Ribble Valley Borough Council
Housing & Development Control

Application no: **3/2021/0710**

Address: **Lodematic Ltd Primrose Works Primrose Road Clitheroe BB7 1BS**

Proposal: **Variation of Condition 2 (Plans) of planning permission 3/2019/0954. Proposed change of Apartment 3 from a two-bedroom apartment to a three-bedroom apartment. Reconfiguration of car parking arrangements.**

A1.16A

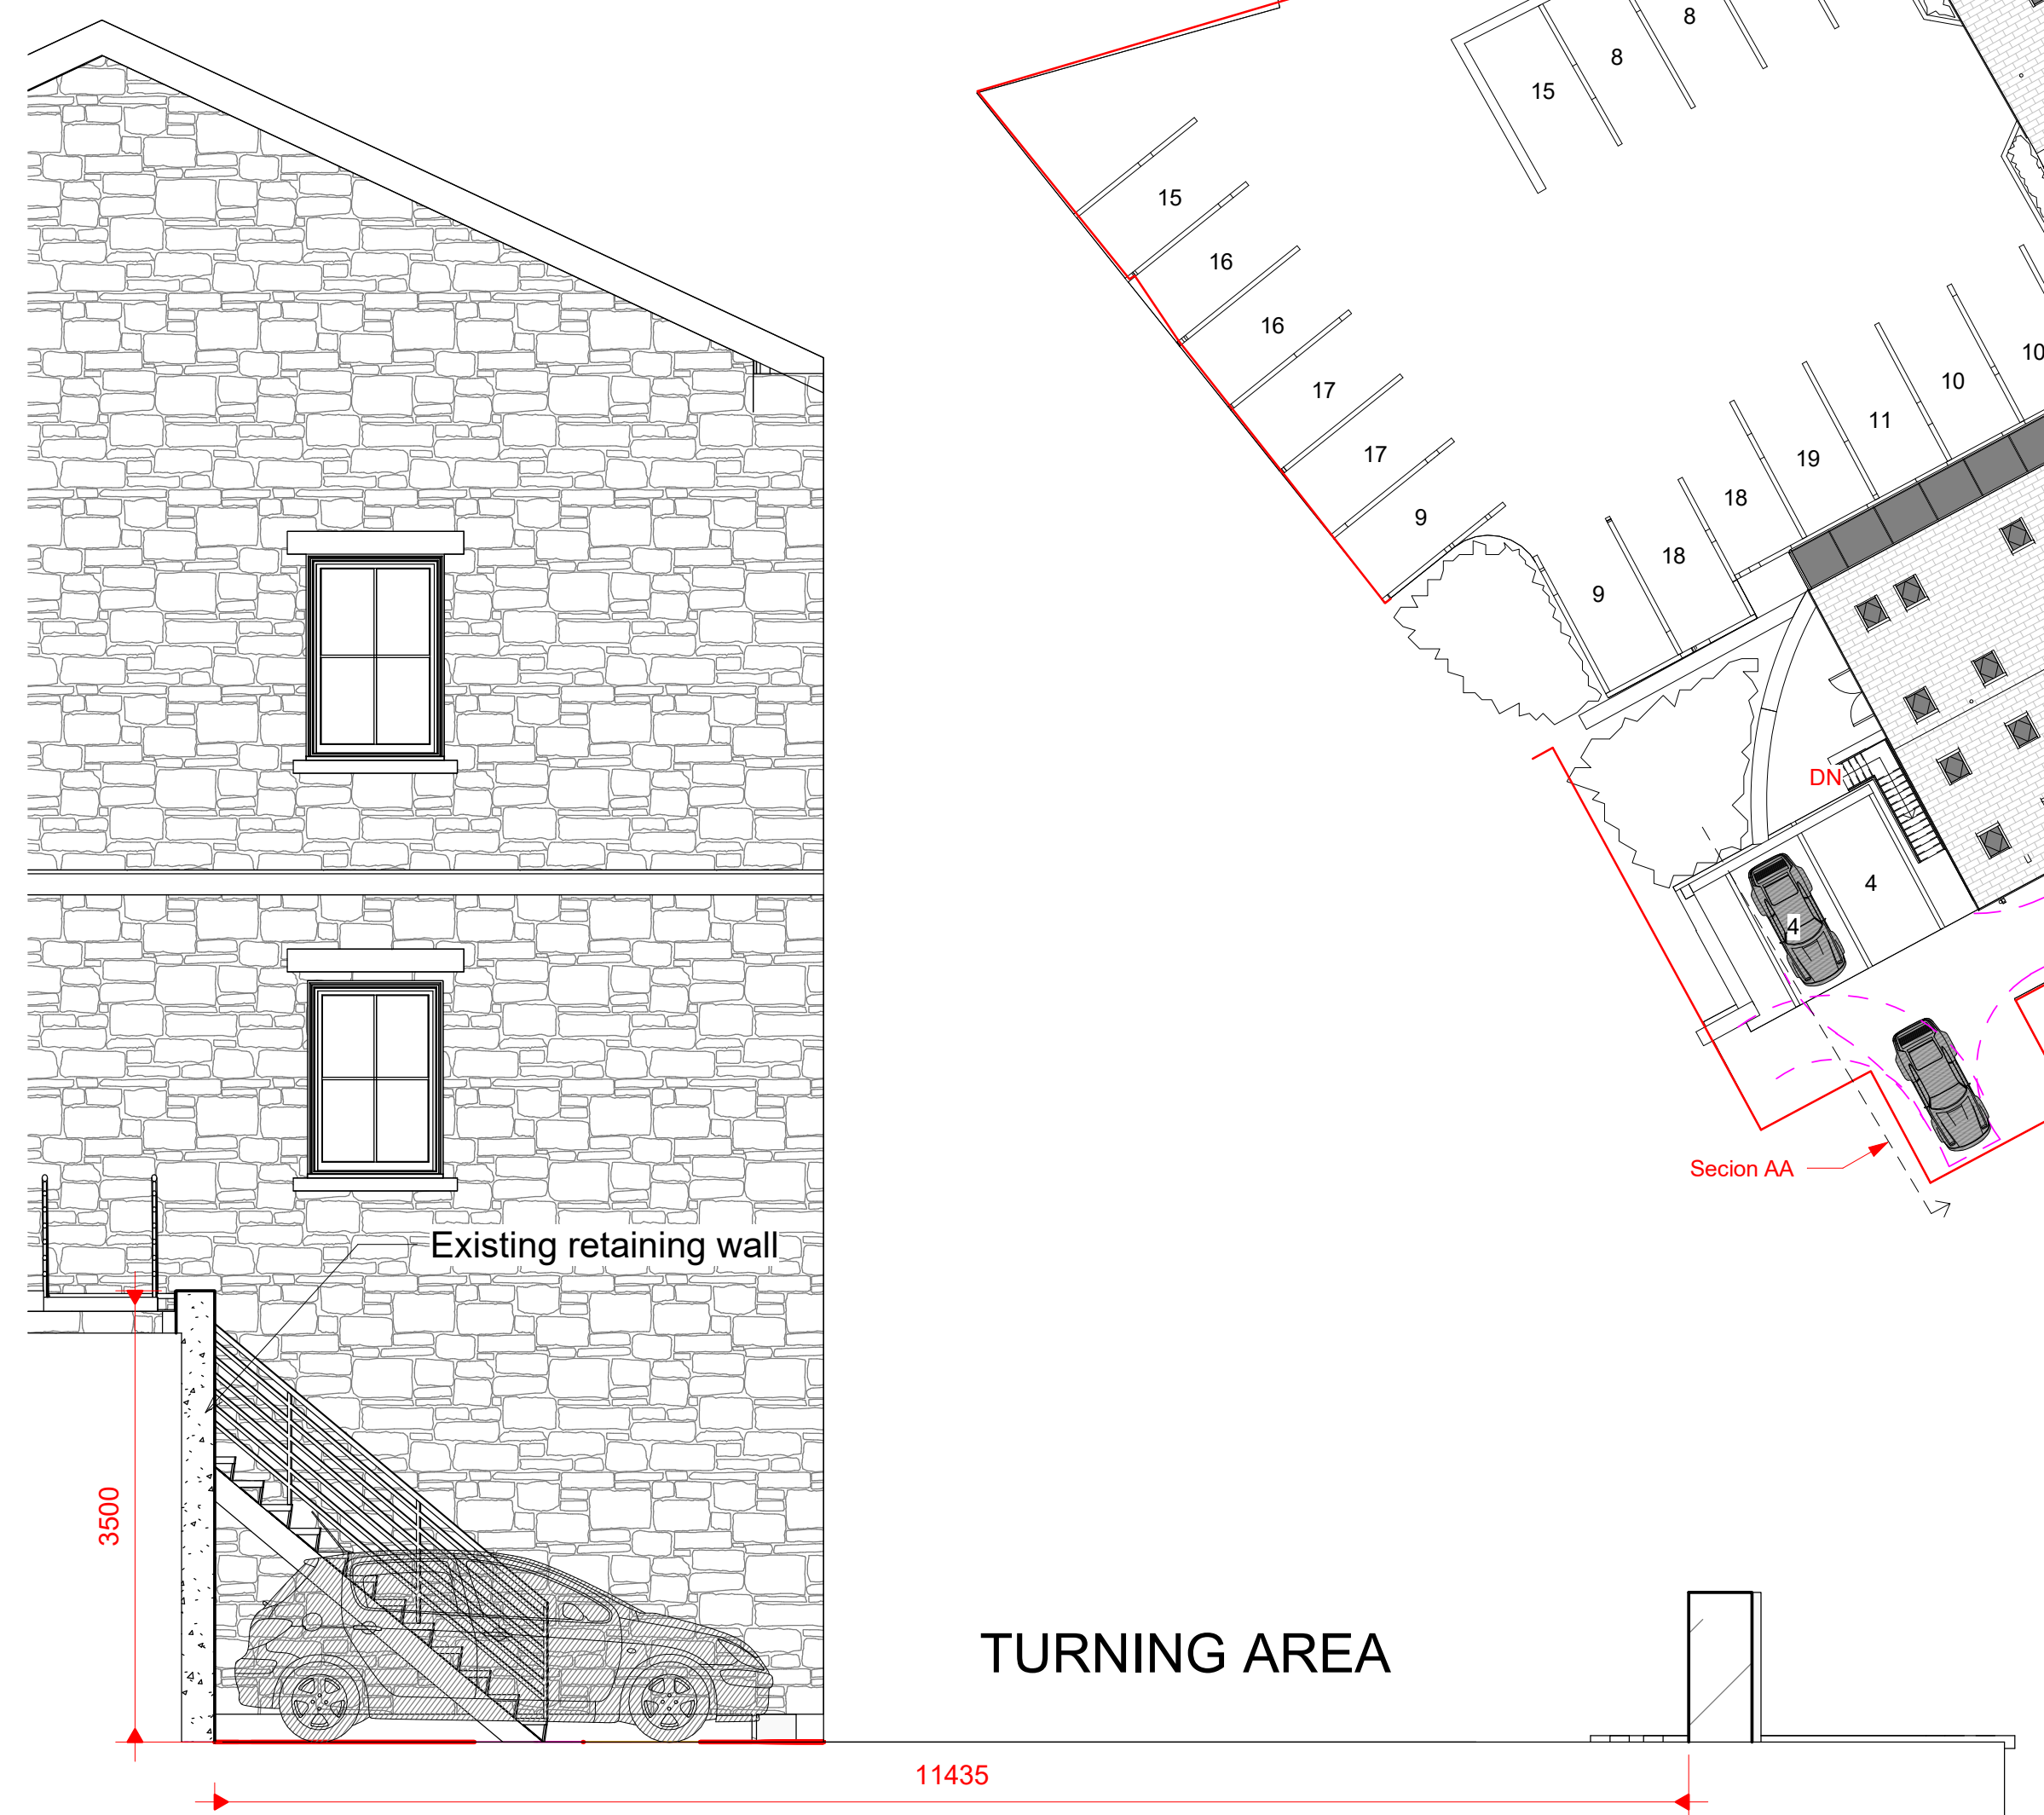
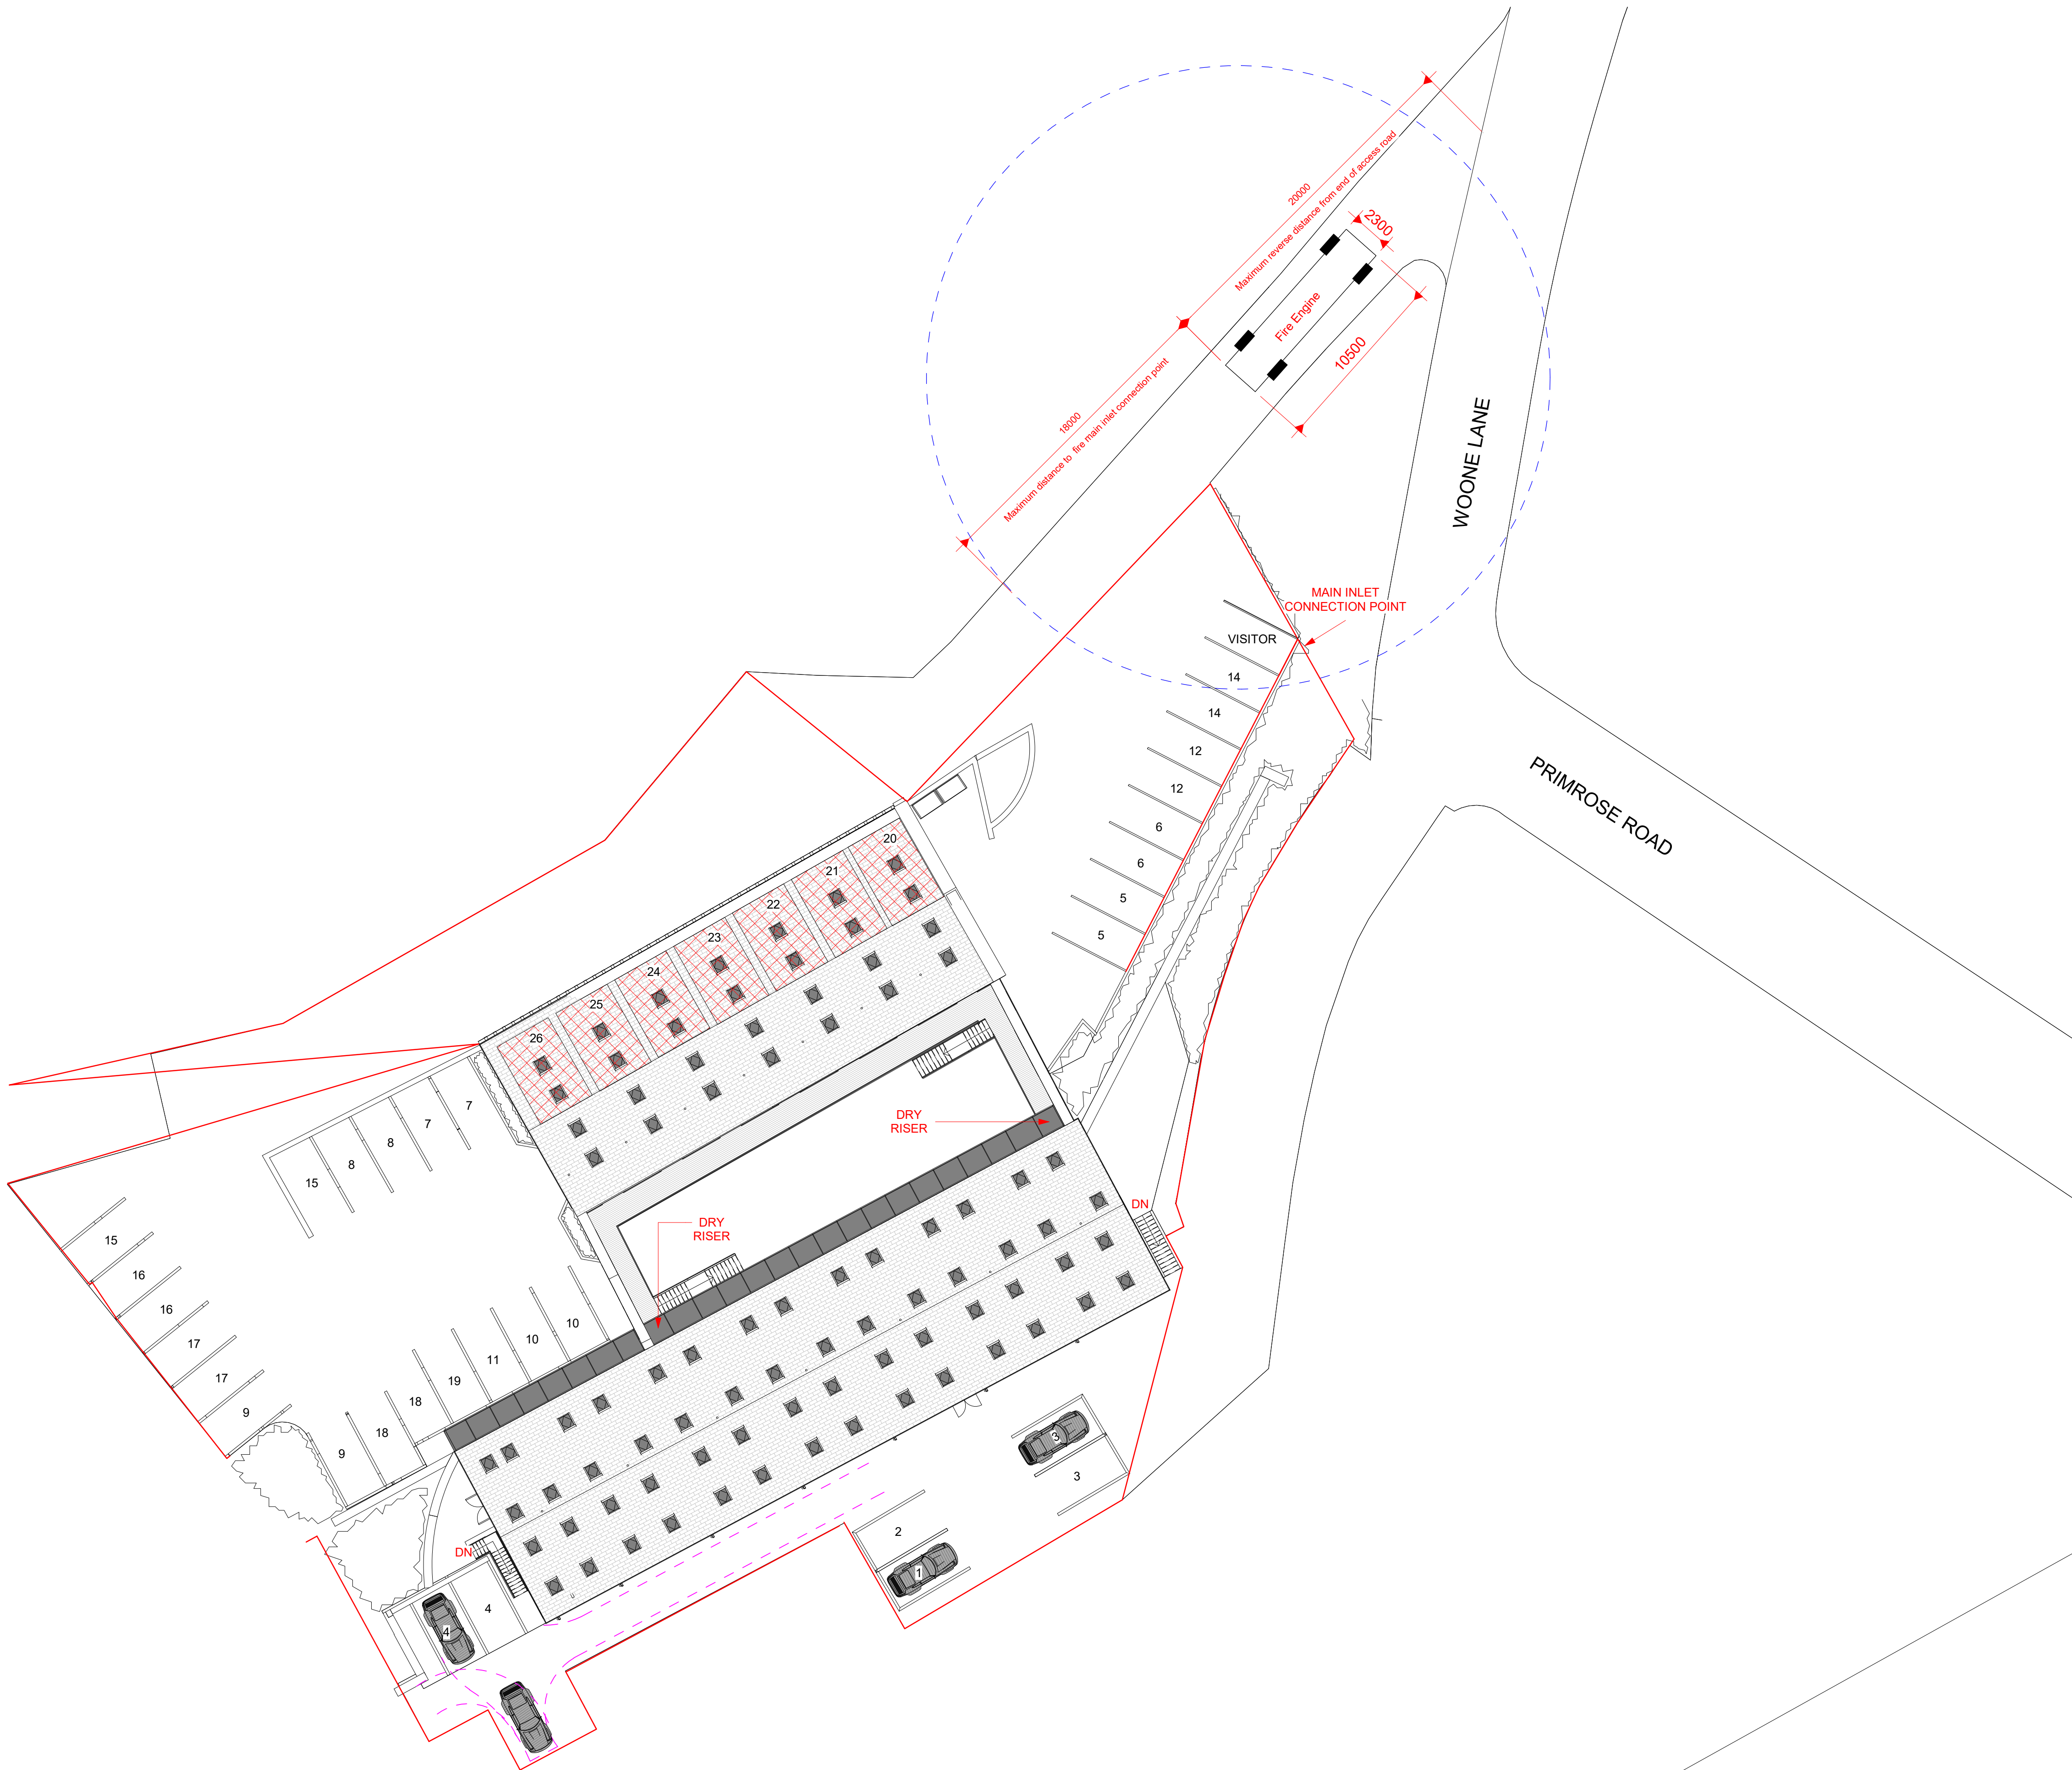
The LHA have reviewed Peter Hitchen drawing number A1.16A titled "Proposed Parking Arrangements" and have no objection to the variation of condition. This is because the dimensions of the spaces comply with the LHAs guidance.

The LHA do note, however, that the parking space closest to the building which belongs to flat 5 should be removed. This is because the LHA are concerned that there isn't the required space for vehicles to reverse out of without conflicting with the building.

The LHA would normally, as result, object against the parking plan but the car park has 2 car parking spaces for visitors. Therefore, one of these spaces should be used for flat 5, leaving one car parking space for visitors which still allows the site to comply with the parking guidance as defined in the Joint Lancashire Structure Plan.

Furthermore, the LHA are also aware of spaces 1 to 3 and the reversing space in this area. As shown on the drawing, there is 5.925m between spaces 1 and 3 for instance, for vehicles to reverse out of the respective car parking space. Usually, the LHA would require a minimum of 6m between car parking spaces to allow vehicles space to reverse out of. However, with the shortfall in the reversing space being minimal the LHA will accept the shortfall and so have no objection to the Variation of Condition.
